SPRINGS EAST AIRPORT FILING NO. 1A

A RE-PLAT OF LOTS 22 & 23, SPRINGS EAST AIRPORT FILING NO. 1, A PORTION OF SECTION 35, TOWNSHIP 13 SOUTH,
RANGE 63 WEST of the 6th PRINCIPAL MERIDIAN, EL PASO COUNTY, COLORADO

REVISIONS			
ZONE	REV	DESCRIPTION	DATE
	1	PCD Comments	06/08/21

SPRINGS EAST AIRPORT FILING NO. 1A

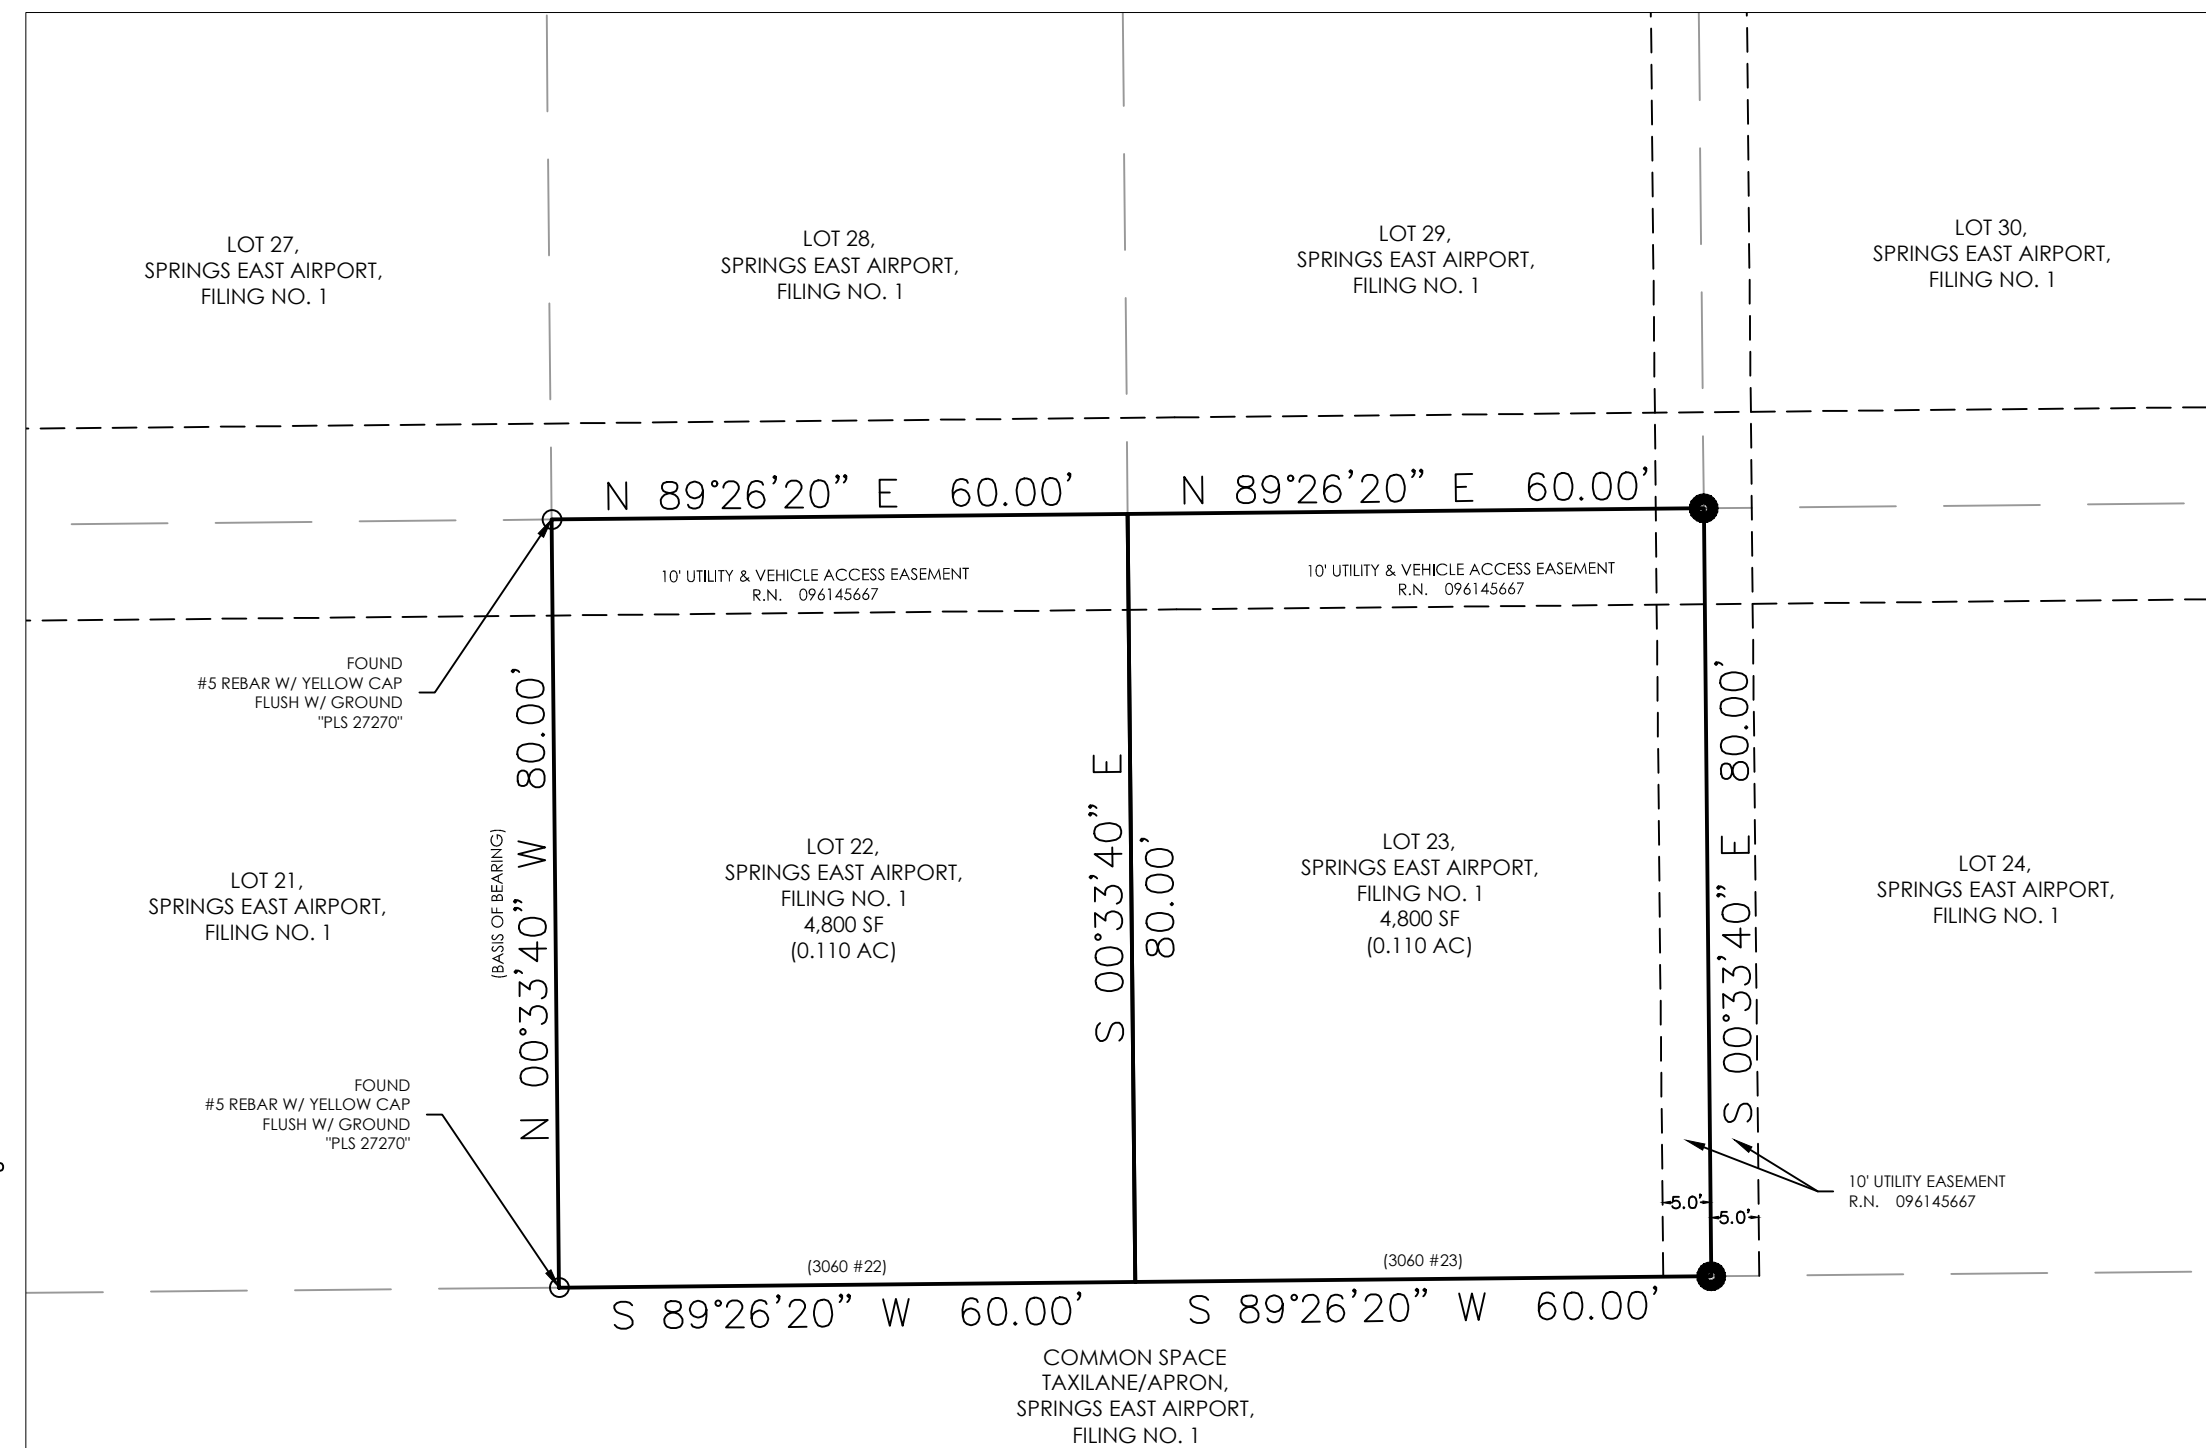
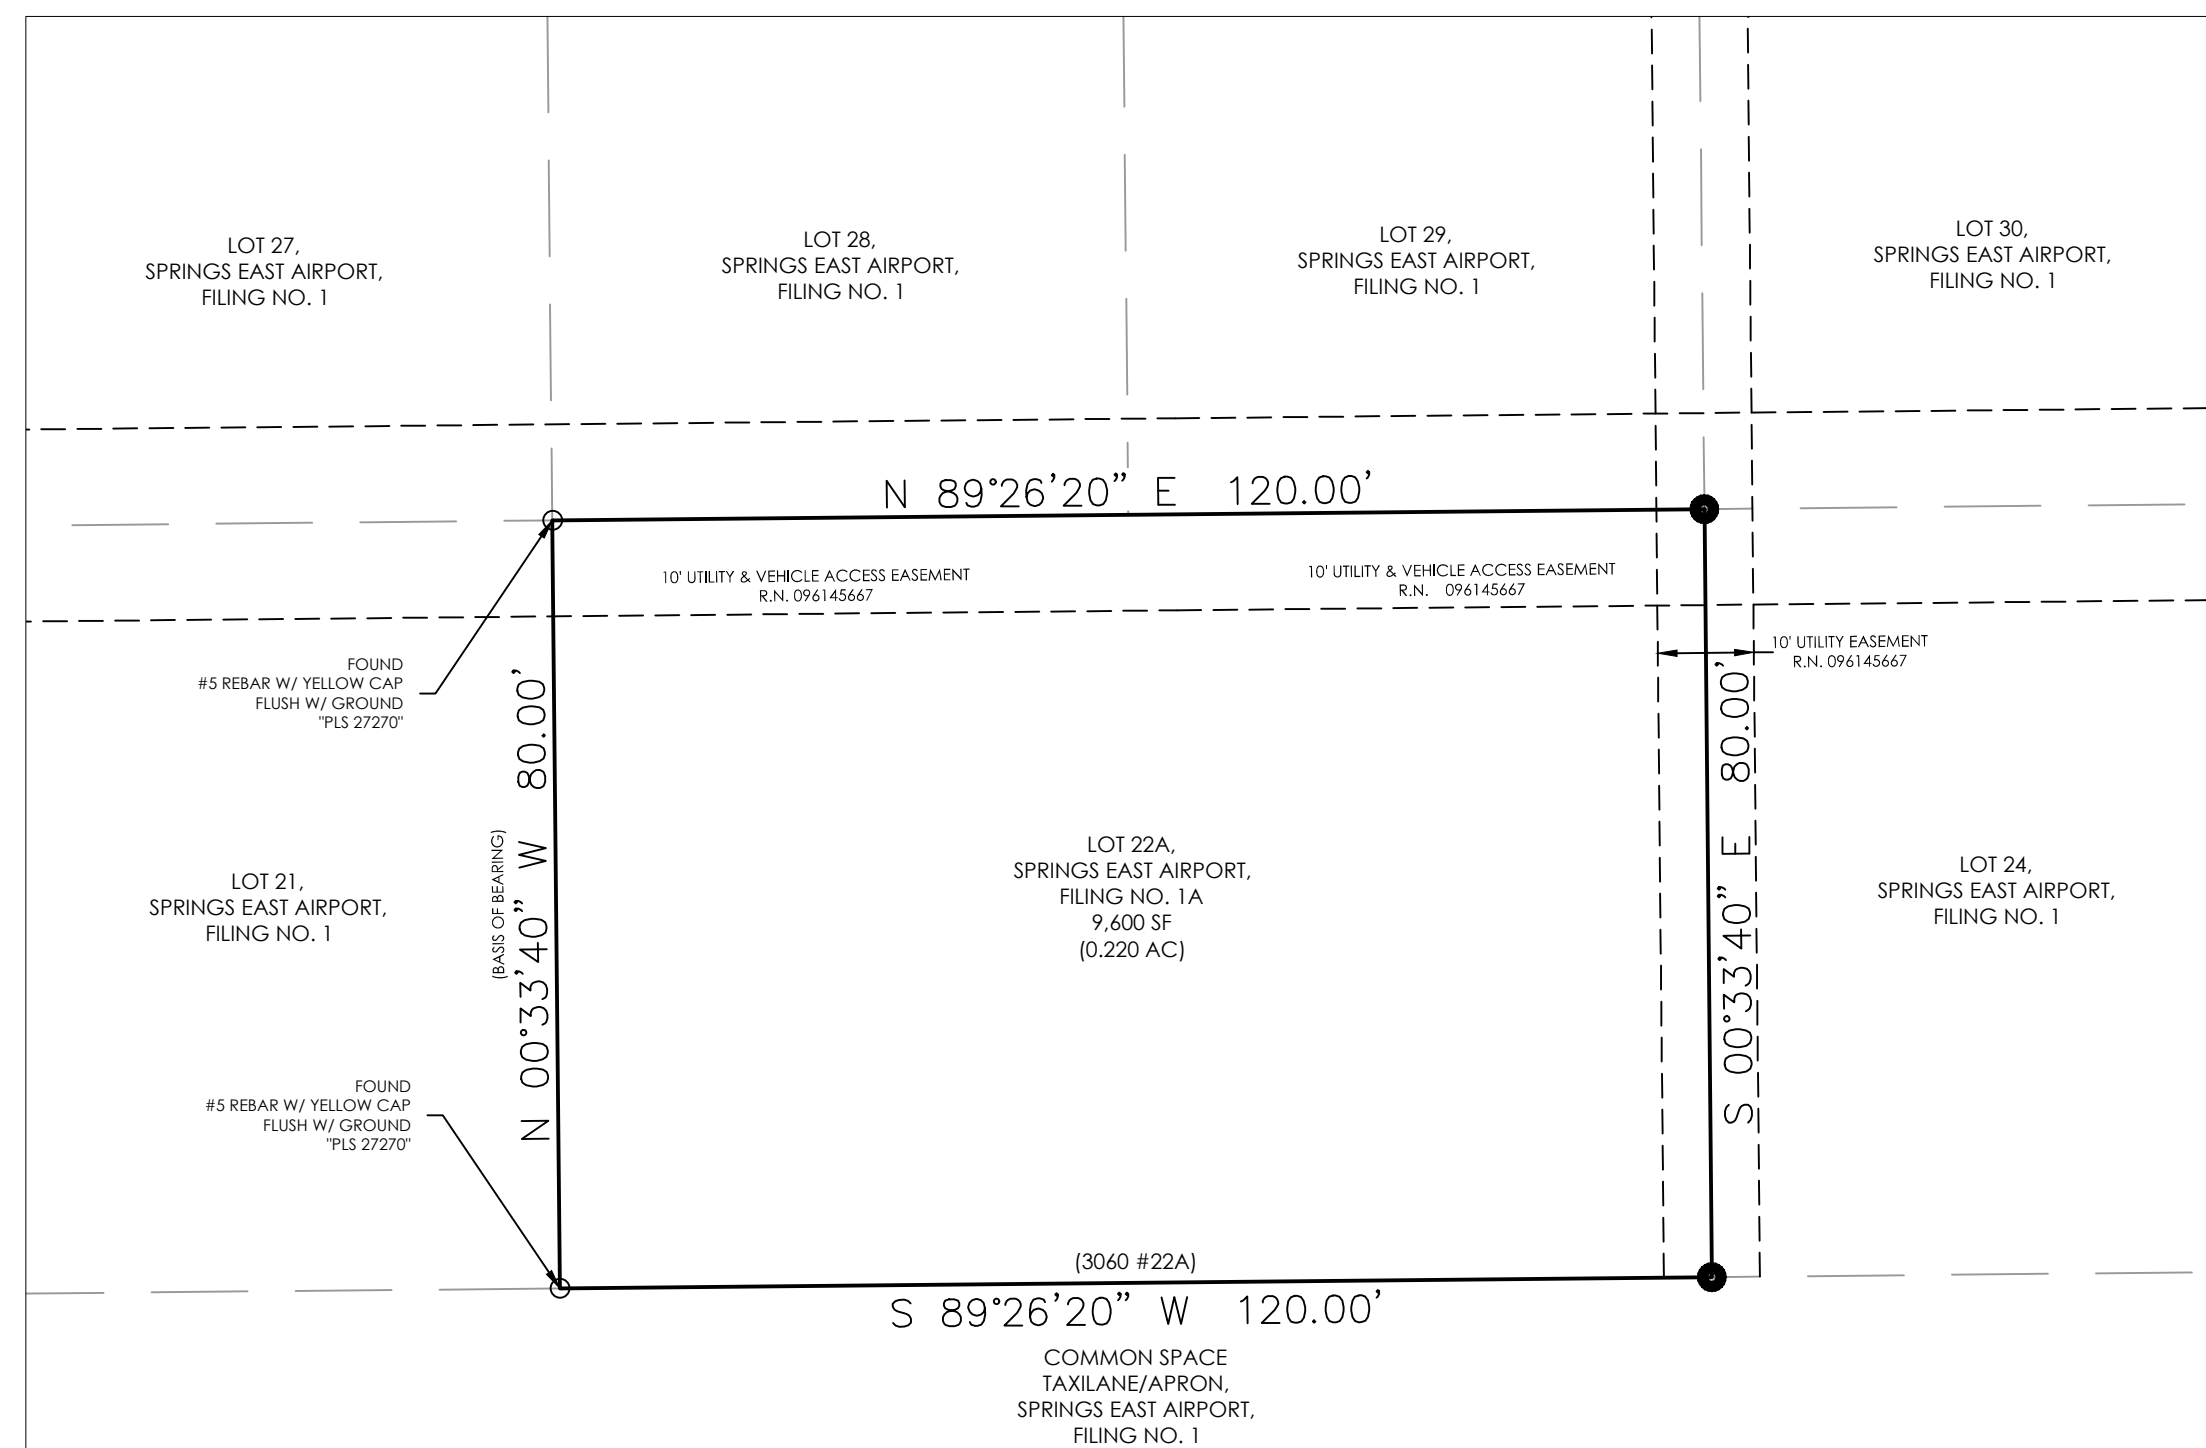
please add the following notes from the previous plat:

9. NO STRUCTURES ARE PERMITTED WITHIN THE DESIGNATED "FLOOD PLAIN".

10. ACCESS TO THE PROPERTY IS VIA AN ACCESS EASEMENT RECORDED AT RECEPTION NO. 96144548 OF THE RECORDS OF EL PASO COUNTY CLERK AND RECORDER'S OFFICE.

EL PASO COUNTY WILL NOT BE RESPONSIBLE FOR THE MAINTENANCE OF SAID ACCESS EASEMENT.

UNLESS OTHERWISE INDICATED EXTERIOR SUBDIVISION BOUNDARIES SHALL HAVE A 20 FT PUBLIC UTILITY AND DRAINAGE EASEMENT. THE SOLE RESPONSIBILITY FOR MAINTENANCE OF EASEMENTS IS HEREBY VESTED WITH THE INDIVIDUAL PROPERTY OWNERS.

please remove all of these signature blocks as this is a vacation by resolution, so they are not necessary.
